Application by Application by Equinor for an Order Granting Development Consent for the Sheringham and Dudgeon Extension Projects

Broadland District Council – Response to S56 Consultation Sheringham Shoal Offshore Wind Farm Extension Project and Dudgeon Offshore Wind Farm Extension Project

Proposal: National Infrastructure Application for an Order Granting Development Consent to construct and operate two offshore wind farm generating stations, known as Sheringham Shoal Offshore Wind Farm Extension Project (SEP) and Dudgeon Offshore Wind Farm Extension Project (DEP), both located off the coast of Norfolk (together “the Projects”).

Figure 28: UK Hab Proposed Results Map 28 (Weston Longville to Honingham)

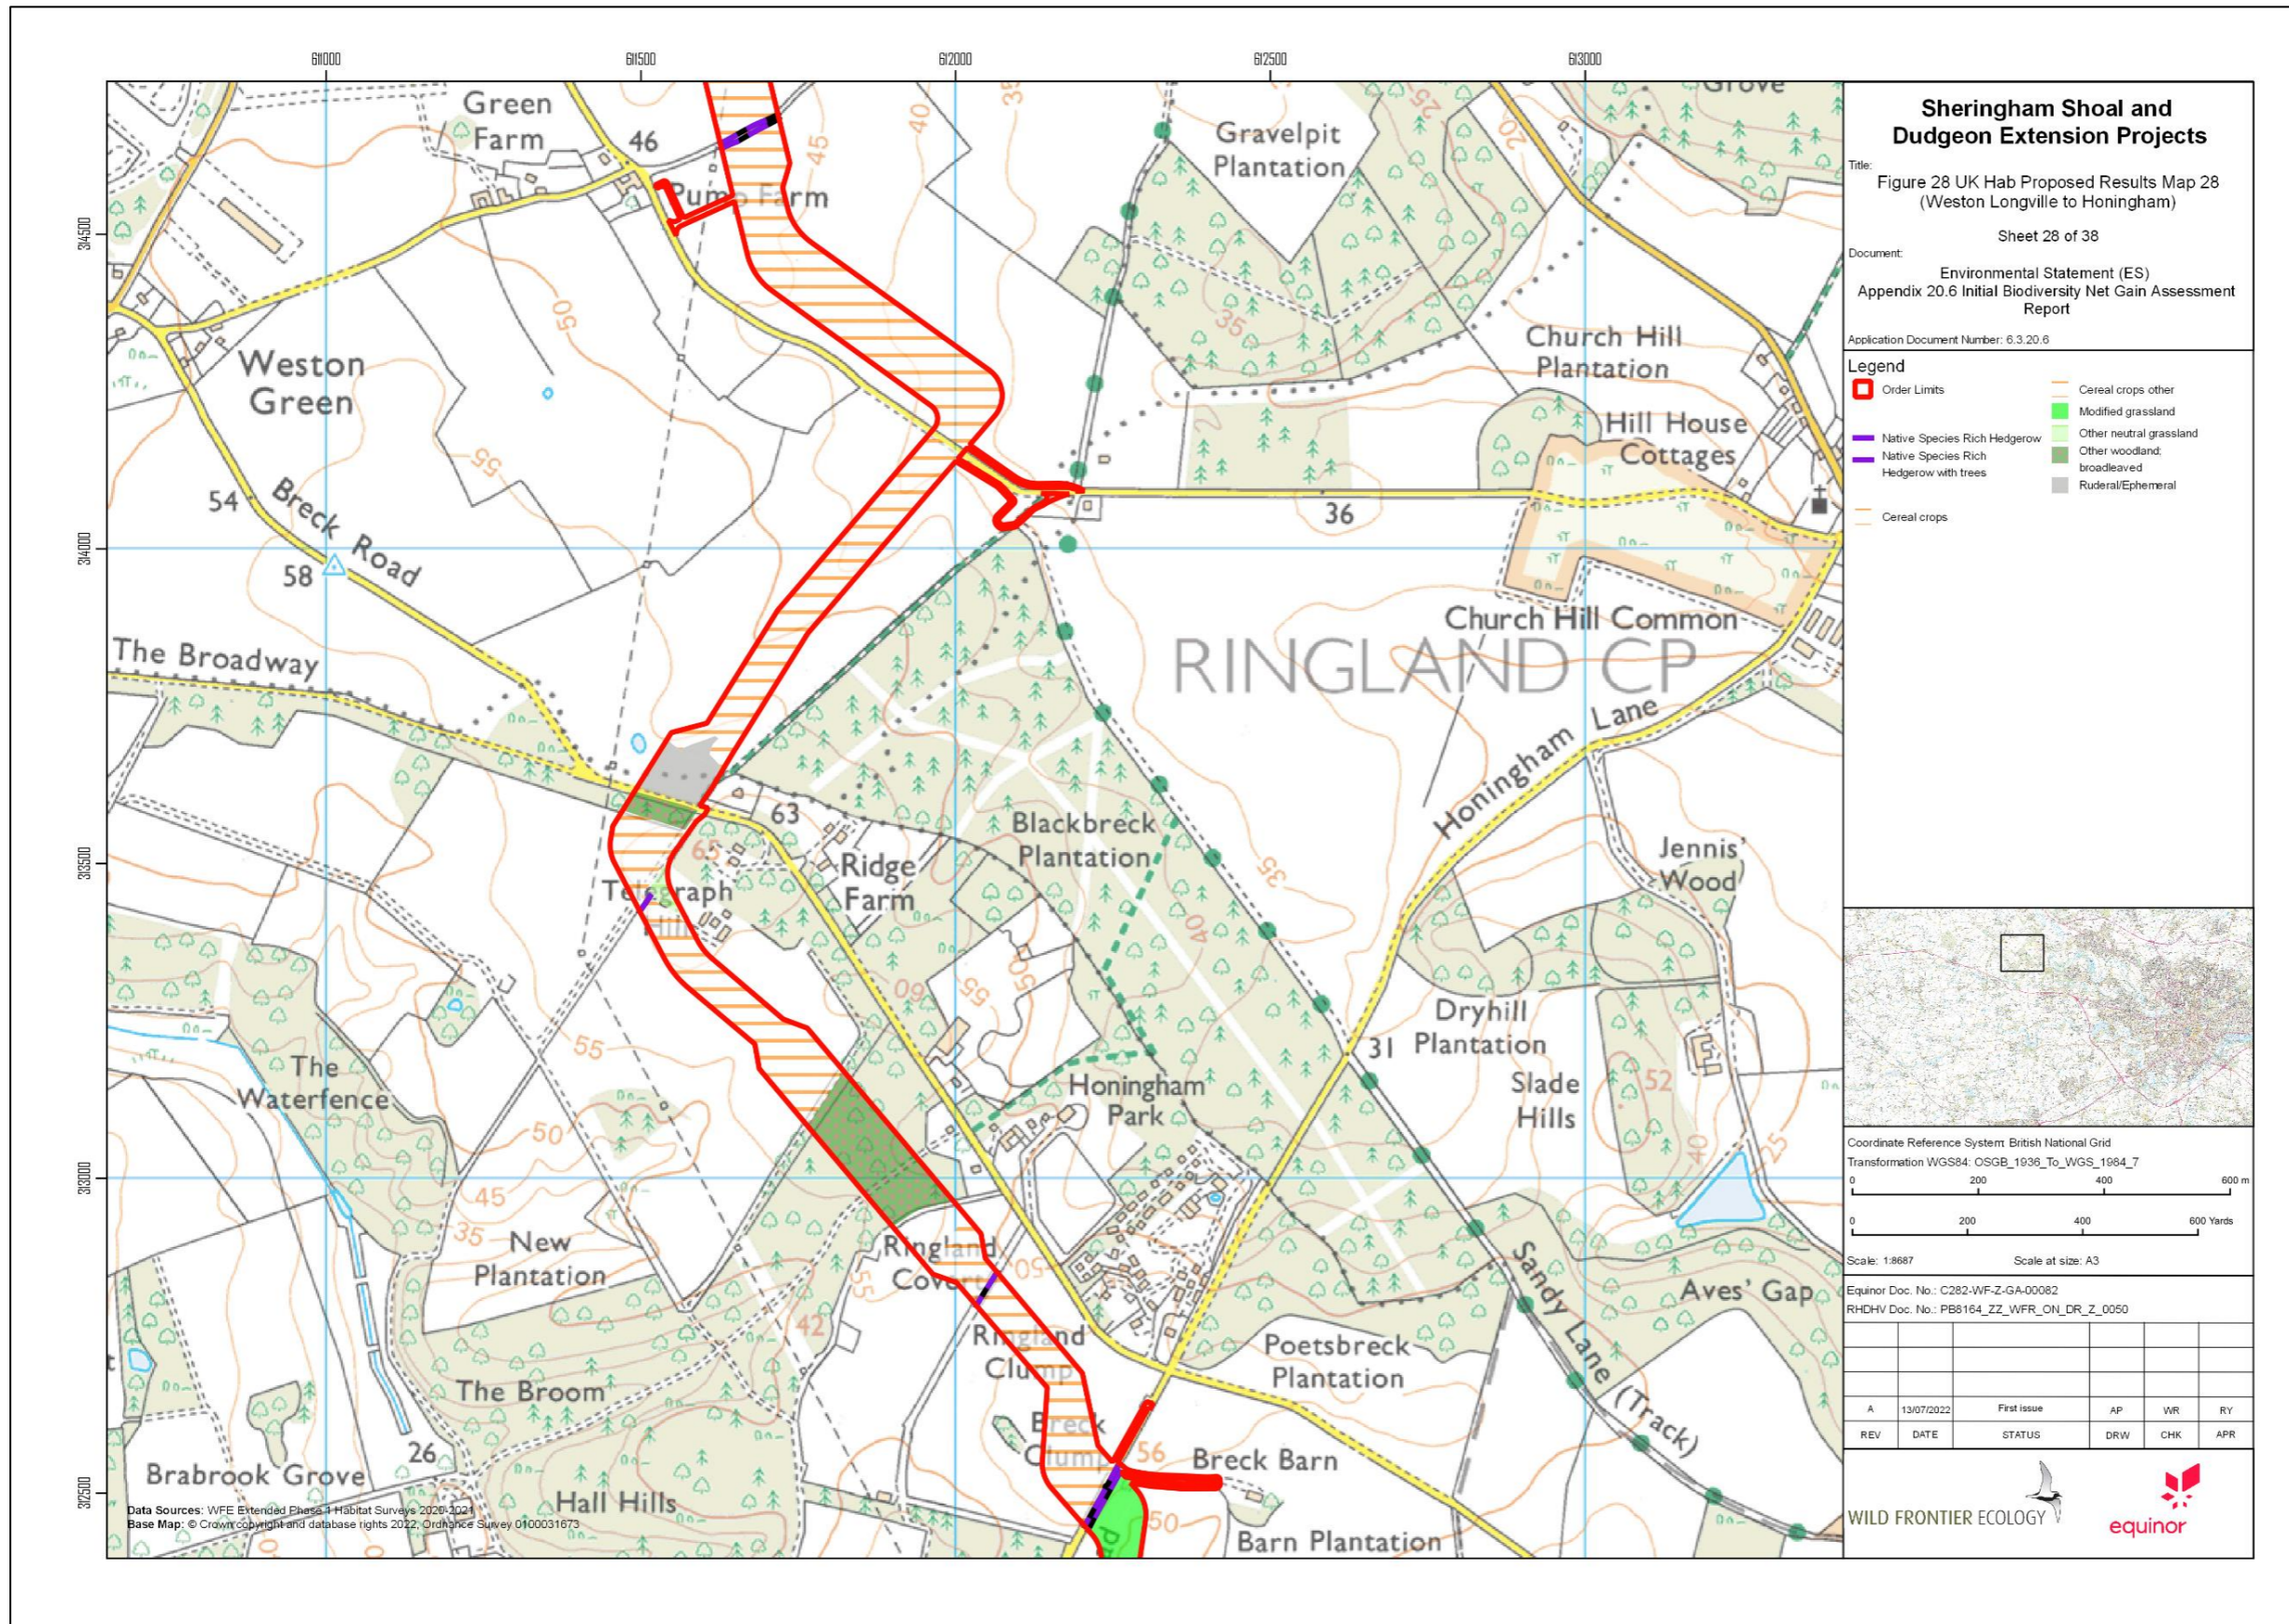
The Council consider that further clarification needs to be undertaken regarding the impact on the project on Honingham Park which is a historic parkland although not registered which is identified on Historic Environment record and can be considered a non-designated heritage asset.

It is also noted as above that the cable route is passing through Honingham Park and the loss of trees could have a harm on the Landscape character of the parkland.
